# KITTITAS COUNTY

### MEMORANDUM

TO: Kaycee Hathaway  
FROM: Christina Wollman, Planner III *CW*  
DATE: July 8, 2014  
SUBJECT: NMF Enterprises CU-14-00002

Hanson Short Plot Amendment
13-00008, Lot 1A, SEC 18, TWP
19, RGE 16

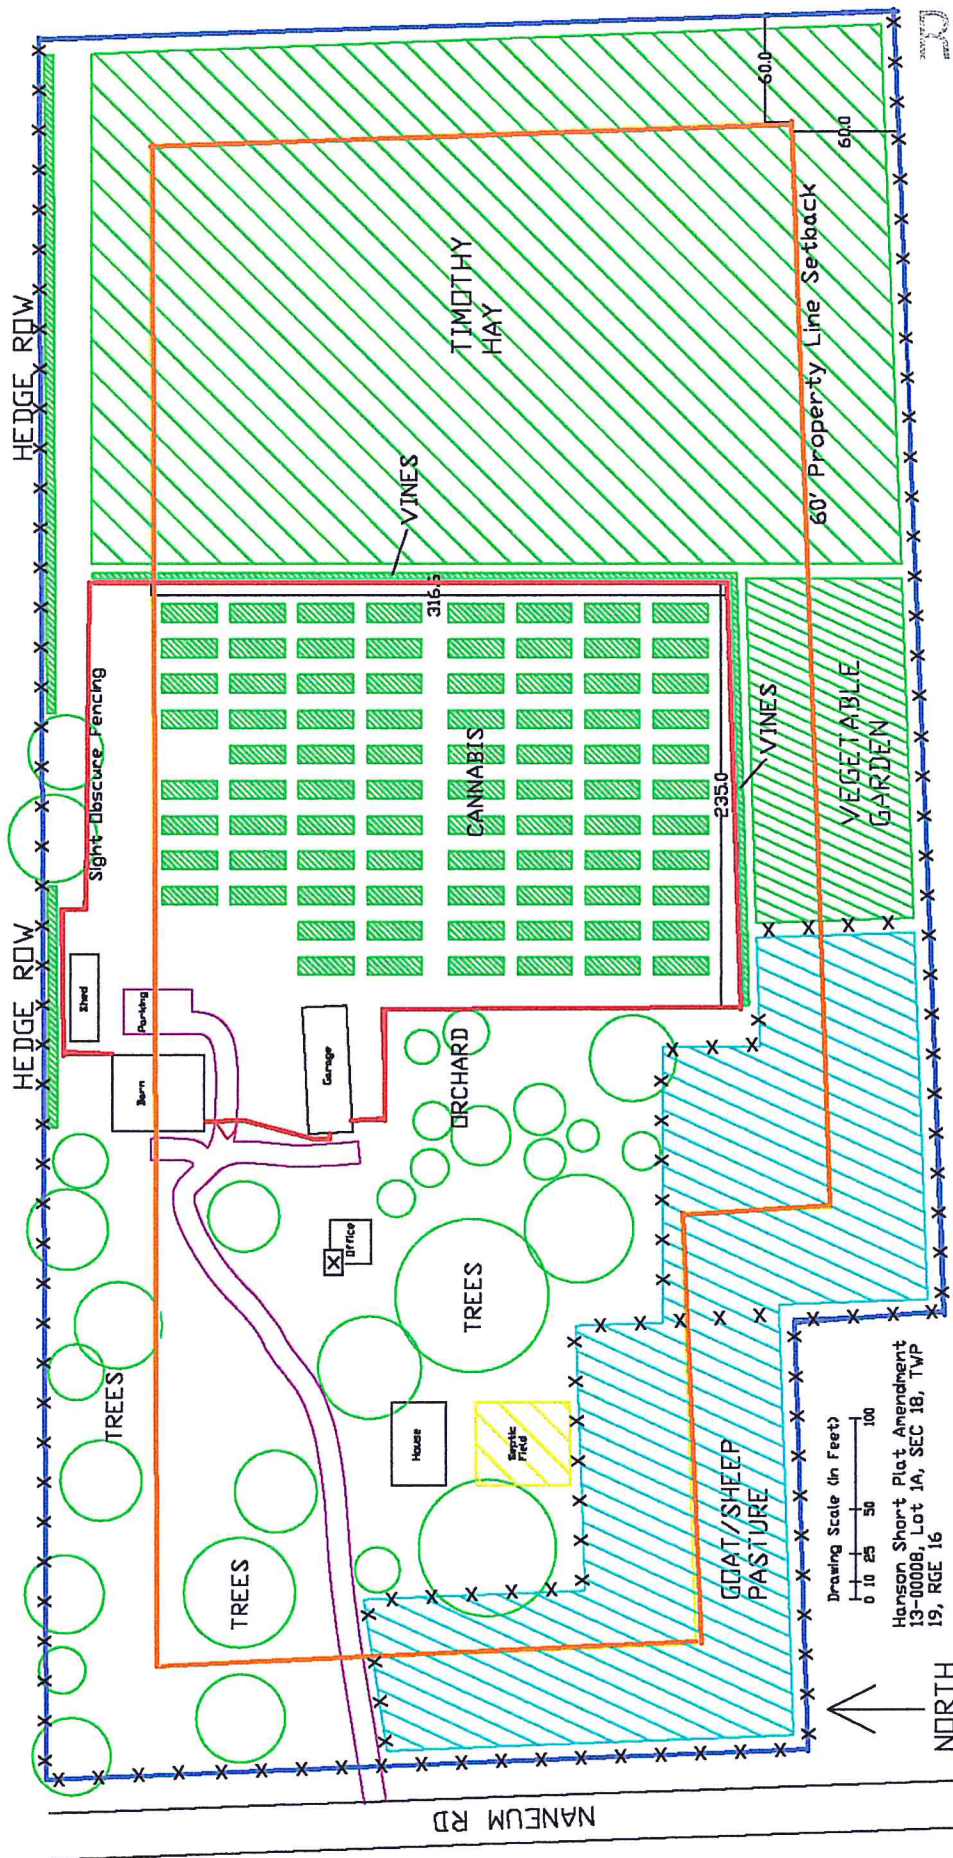
- A. Transportation Concurrency: A Determination of Concurrency Finding has been issued for this project under number TC-14-00002. No mitigation is required of this project.
- B. Site Access: The driveway must be constructed to commercial standards, as shown in the WSDOT Design Manual Exhibit 1340-2.
- C. Access Permit: An approved access permit shall be required from the Department of Public Works prior to alteration of the existing access. No new accesses will be allowed.
- D. Addressing: Contact the Kittitas County Rural Addressing Coordinator at (509) 962-7523 to obtain addresses prior to obtaining a building permit. A parcel cannot receive a building permit or utilities until such parcel is identified with a 911 address.
